Application No: BE/104/21/PL
Site Address: Land Adjoining the Tesco Express 351 Chichester Road Bognor Regis PO21 5AN
Description of works: Erection of 7 No. 2-storey dwellings consisting of 3 No. 2 bed units & 4 No. 3 bed units, access, parking, cycle storage, bin store and other associated landscape works. This site is in CIL Zone 4 & is CIL Liable as new dwellings.

Thank you for your internet representation made on 28th July 2021 which has been recorded as an objection with the comments as follows:

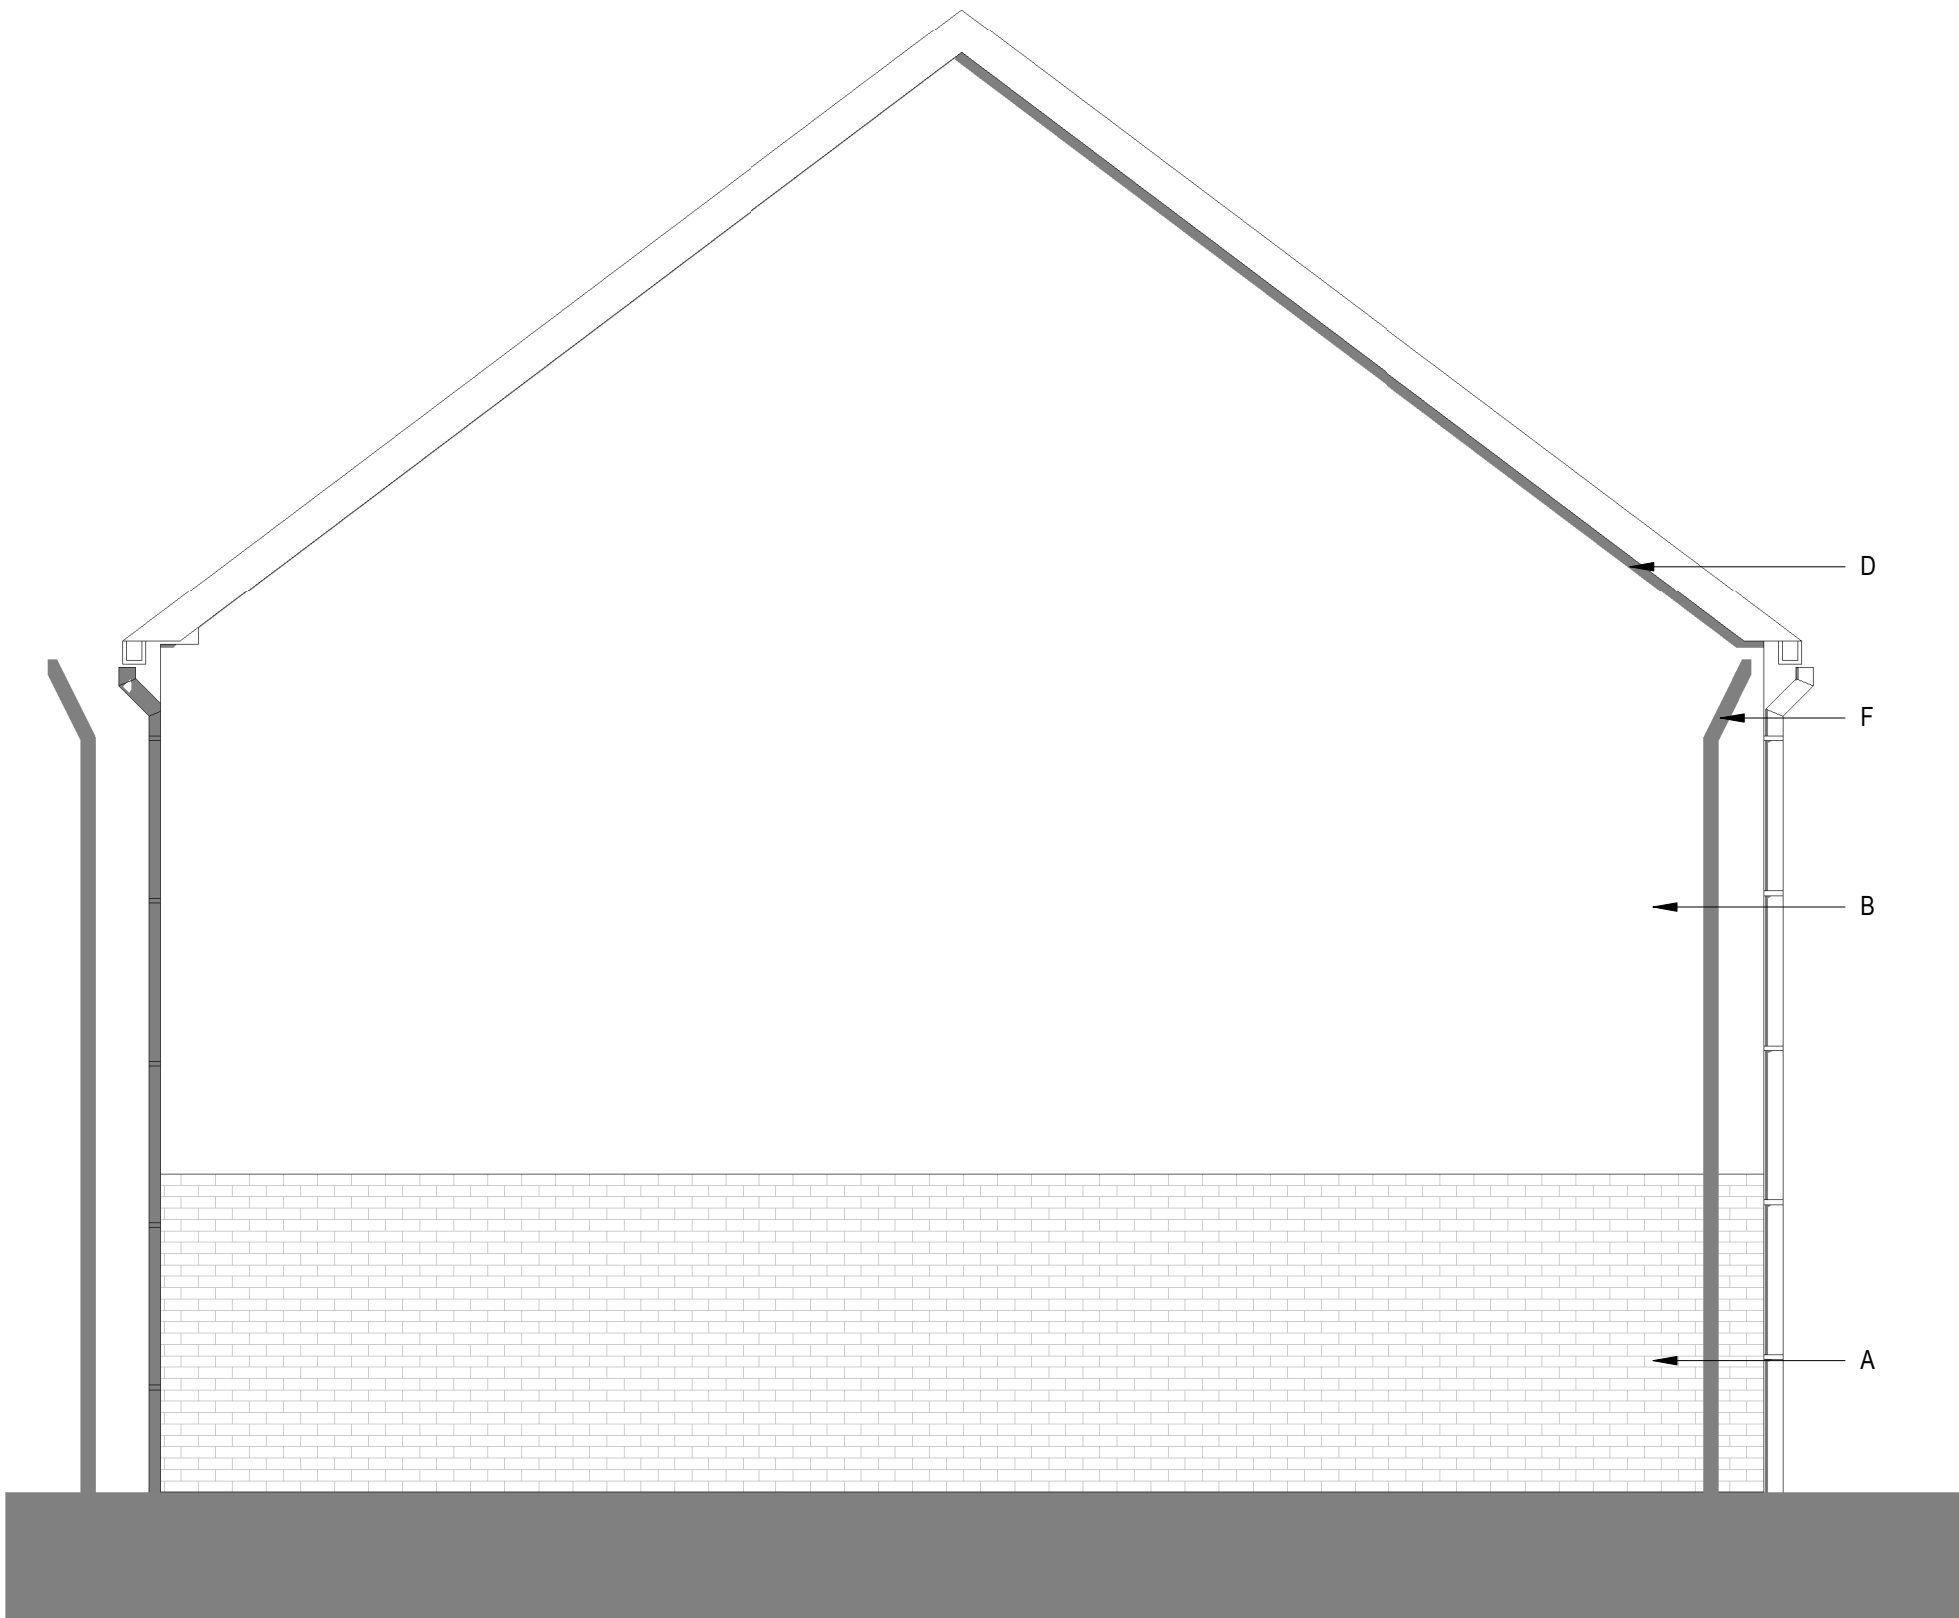
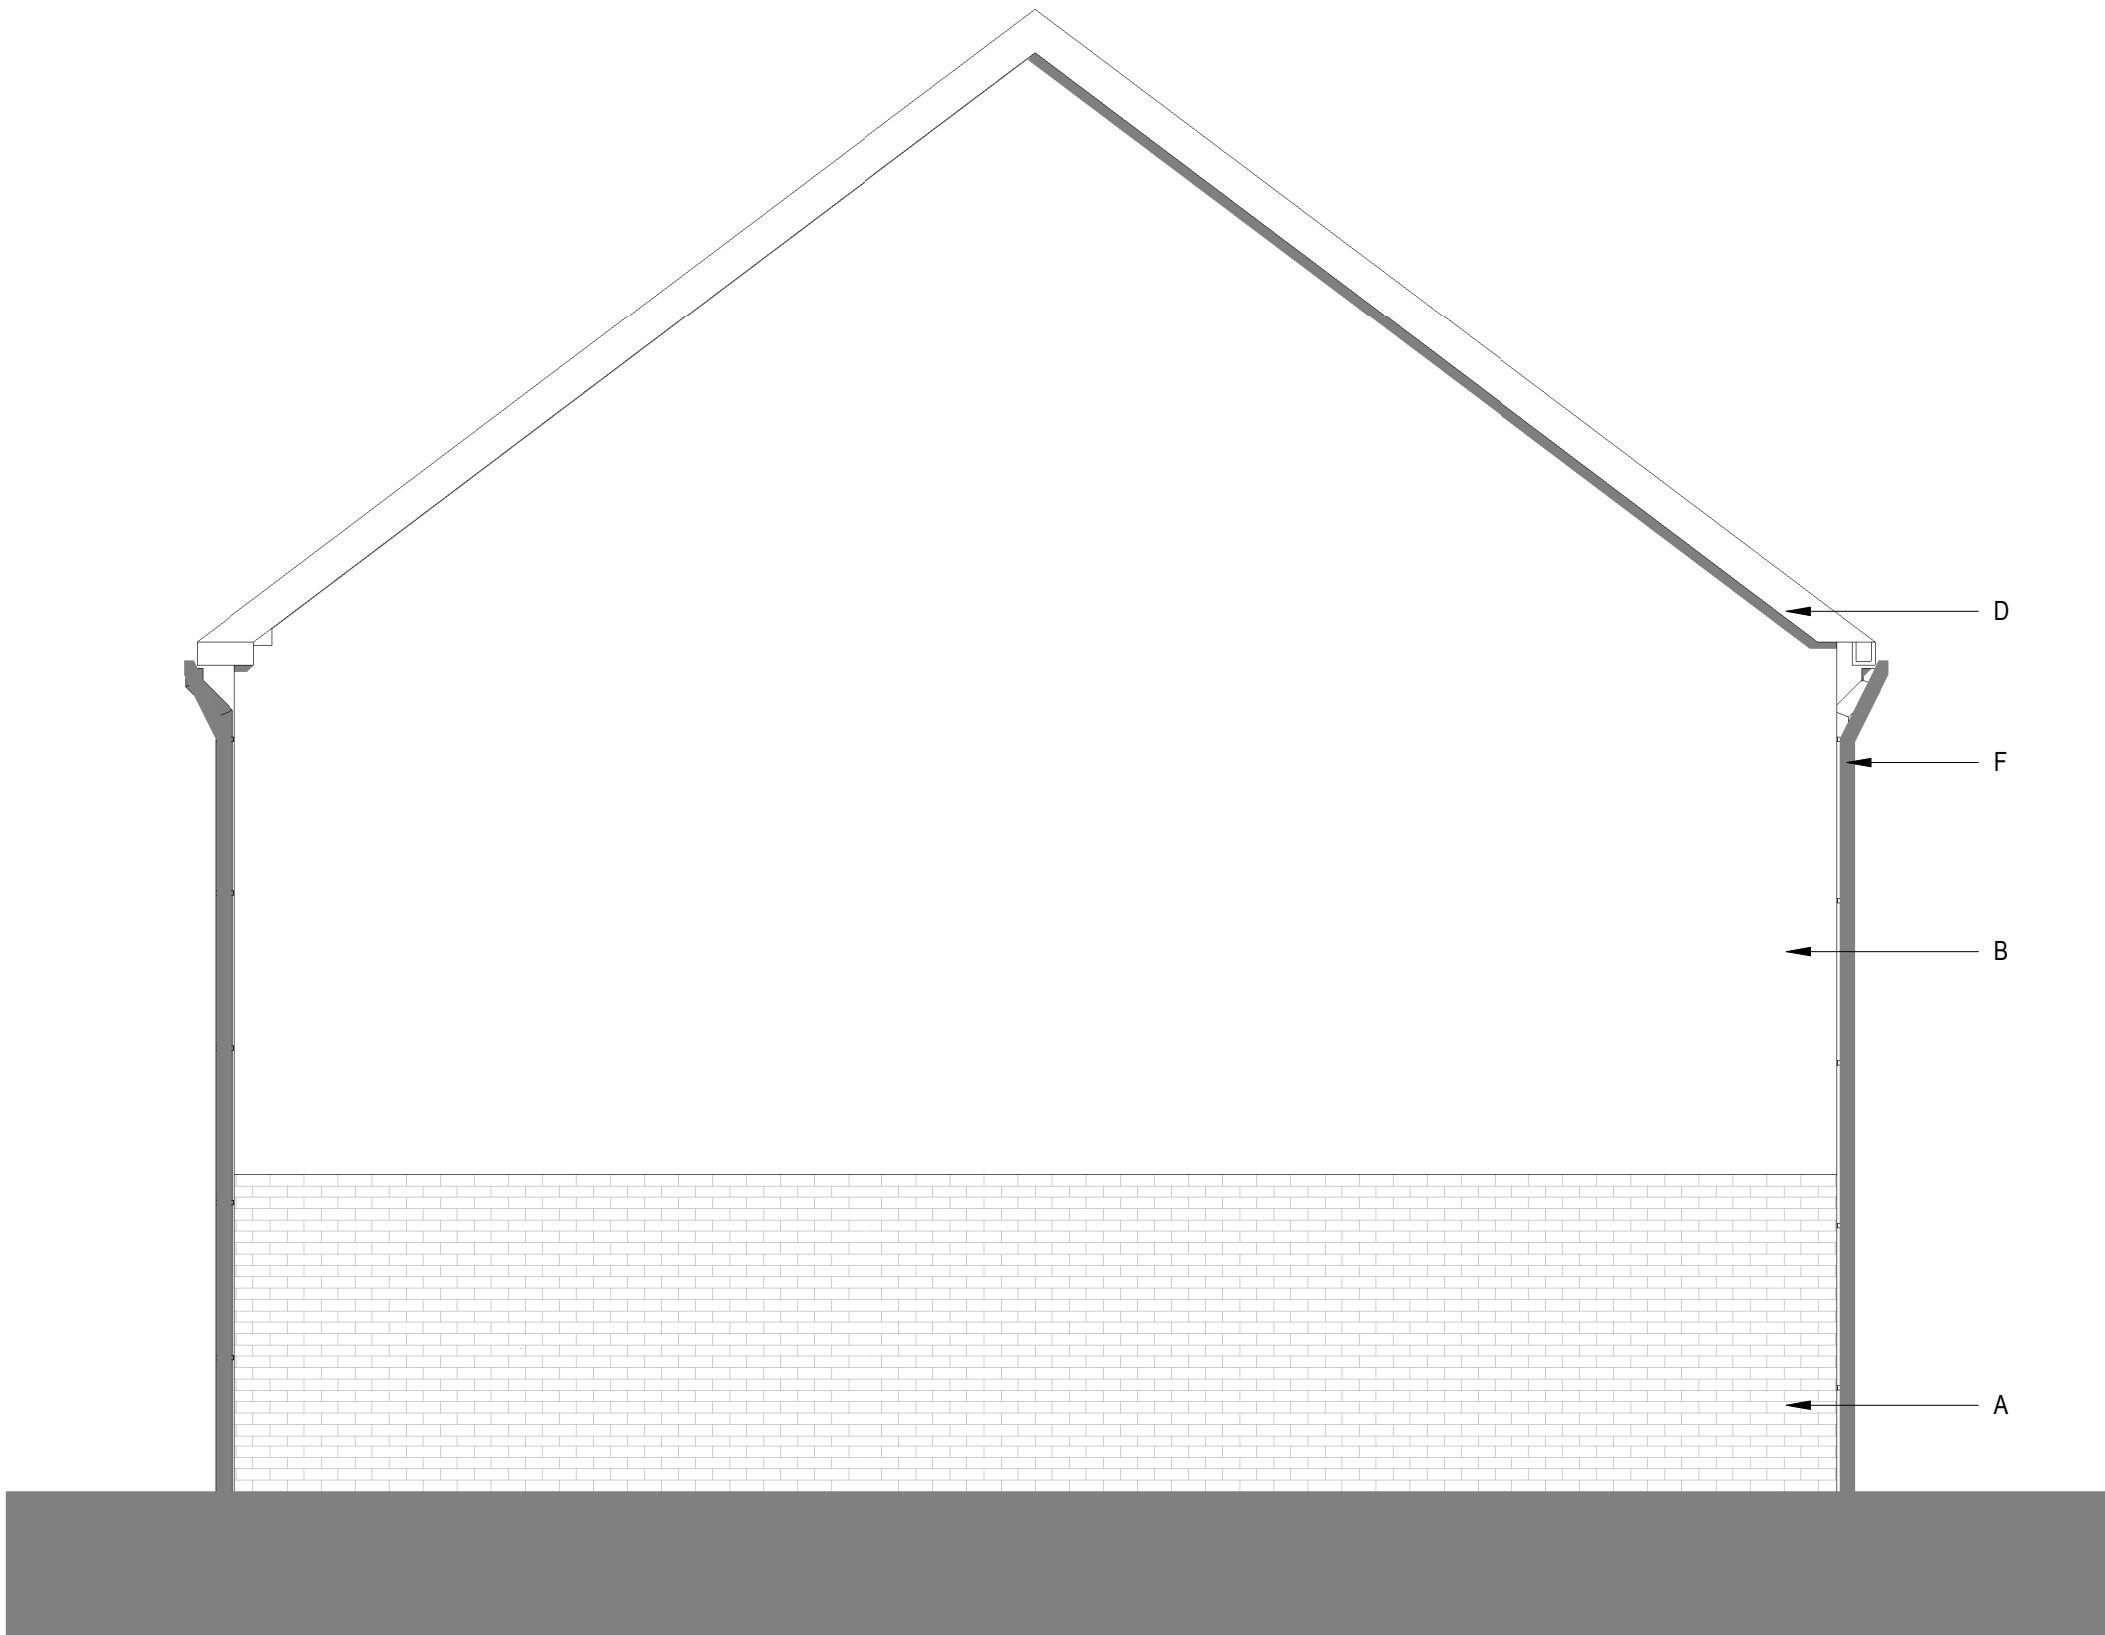
Block B consists of 4 houses that are 3 storeys high. These have 8 windows on the third floor alone! all of which overlooks the gardens and houses in Bedford Avenue. This will have a detrimental effect on the privacy of surrounding properties and also devalue them.
